February 12, 2007

Re: Status of Improvement Permit Application #06-5-15153RR Lt 46 Laurel Valley

SAPPHIRE DRIVE  
 JASON PRICE CONST. INC.  
 THE HANOVER  
 LOT #46 LAUREL VALLEY  
 SCALE: 1"=40'

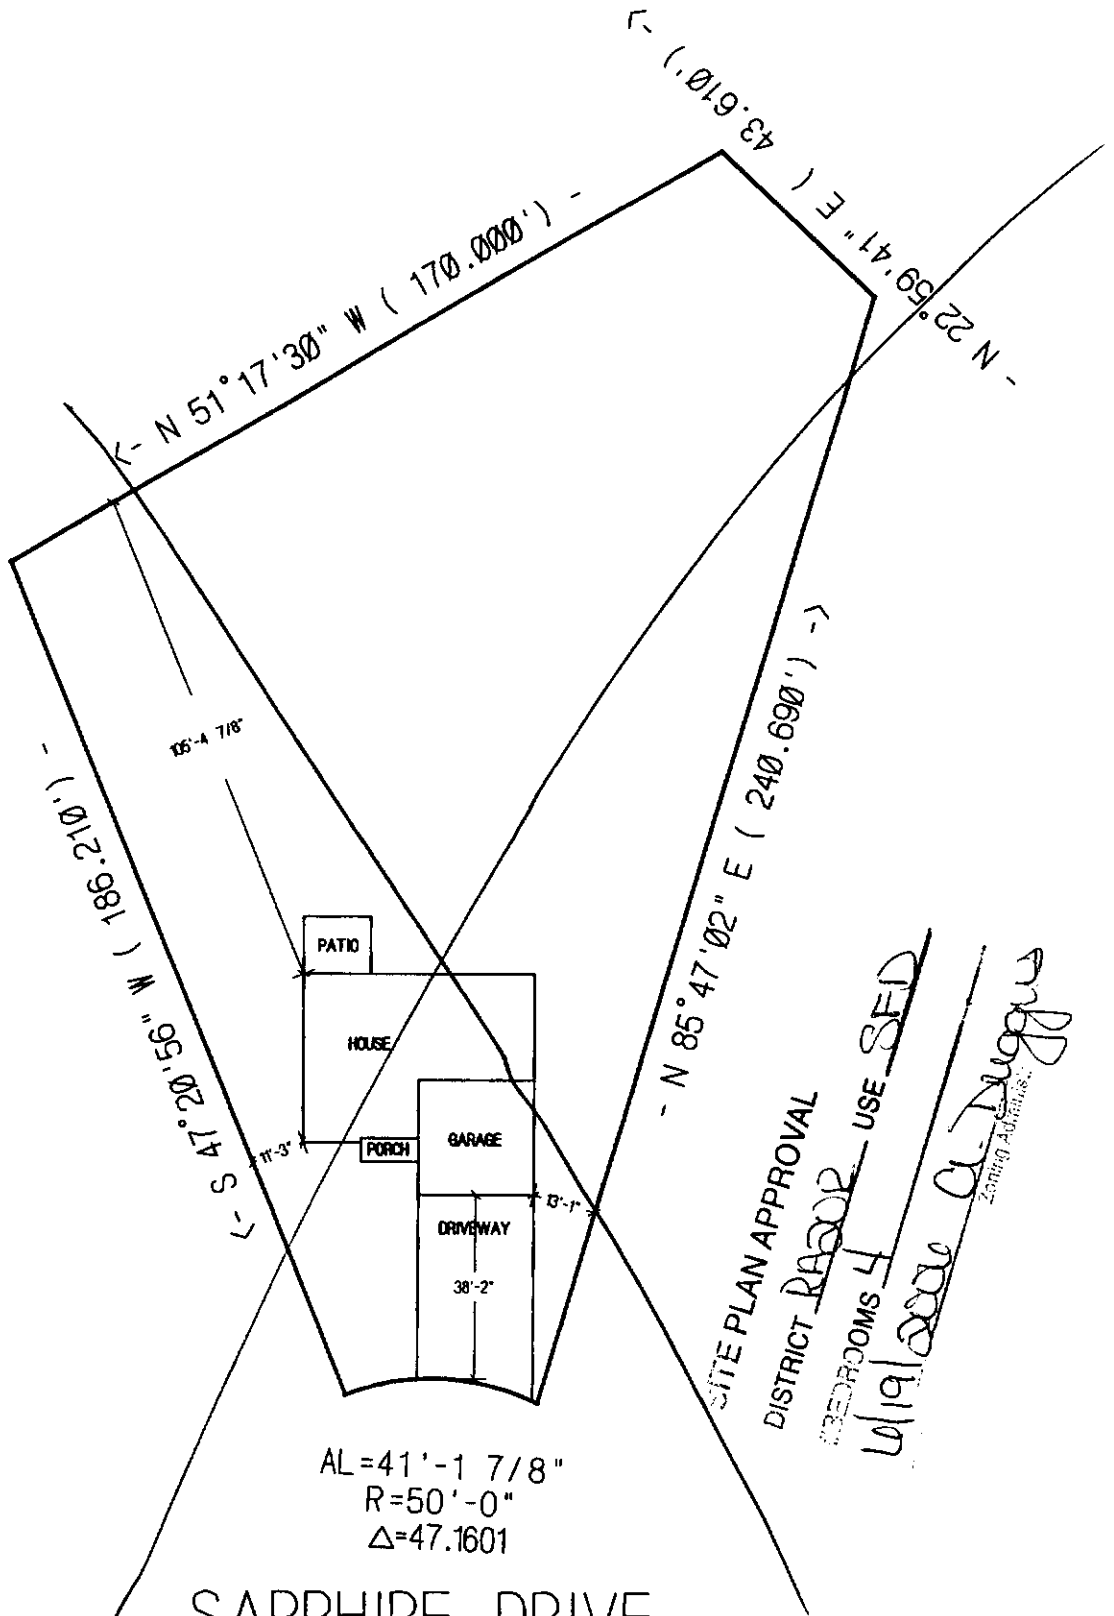
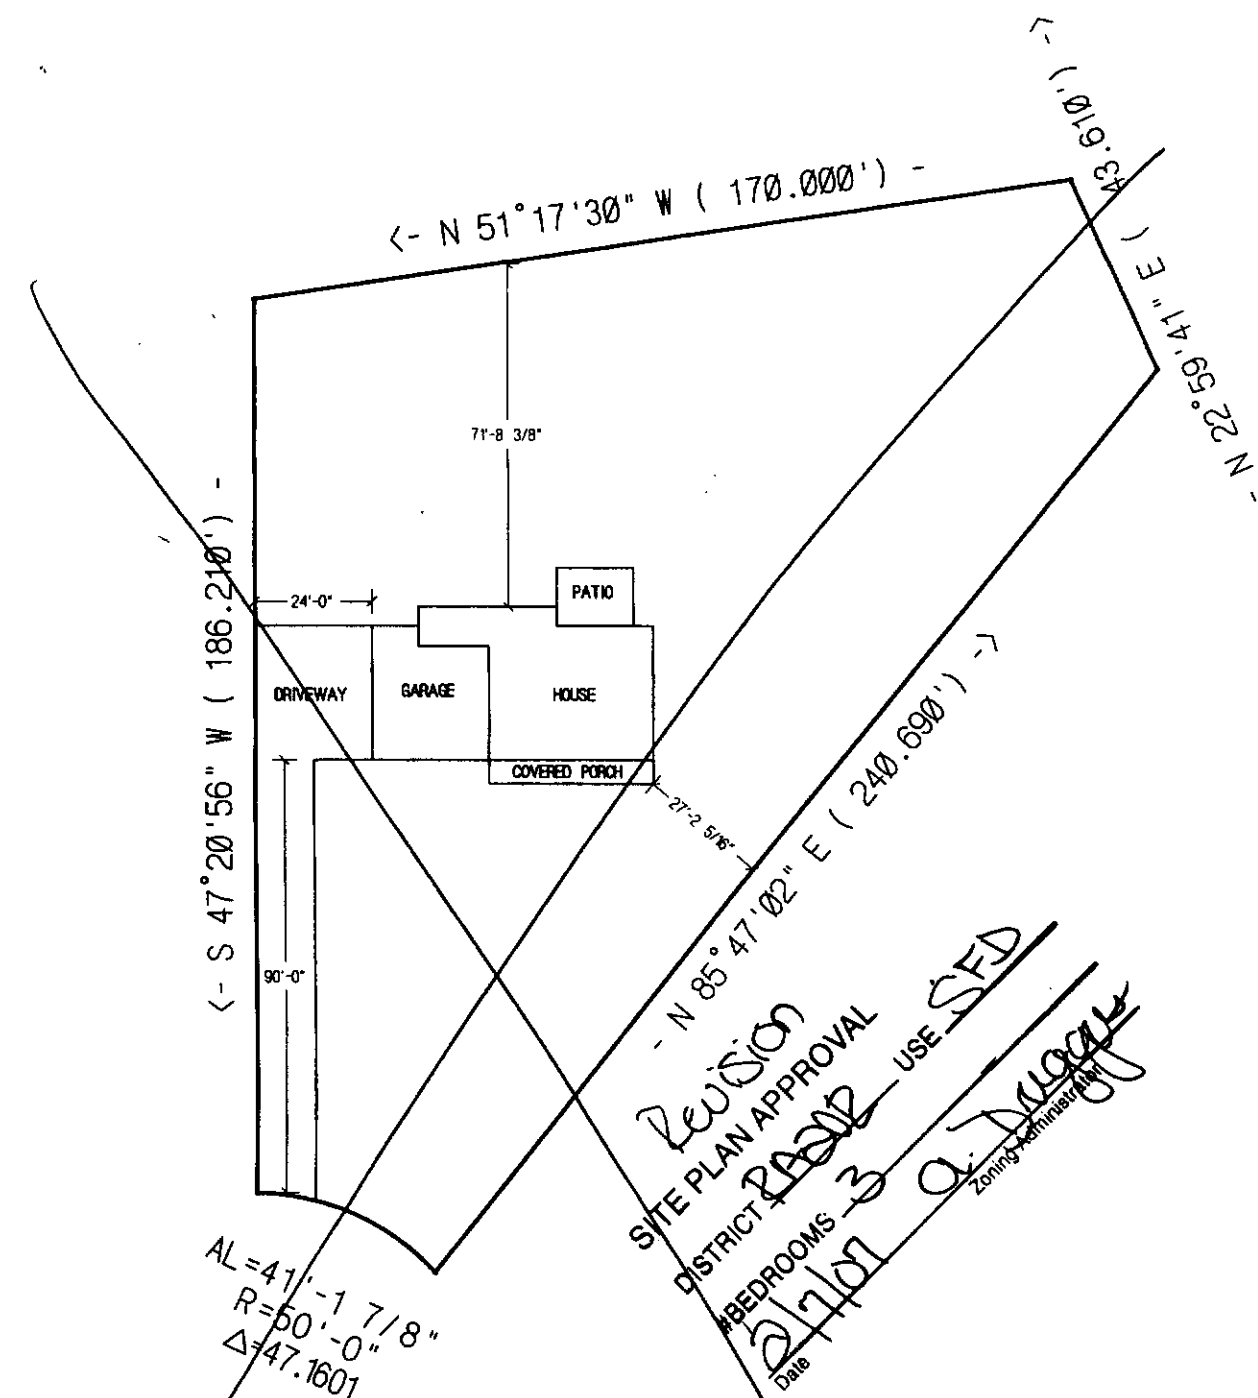
- 1. Property lines/corners not marked or labeled
- 2. House corners not marked or labeled
- 3. Directions not clear to property
- 4. Property needs brush or vegetation removed
- 5. Backhoe pits required
- 6. Other – **Your consultant's layout and house placement has home at least 40' from side line not 27' as shown on your plot plan. Please move home so that it is 40' from property line and resubmit as a revision to Central Permitting.**
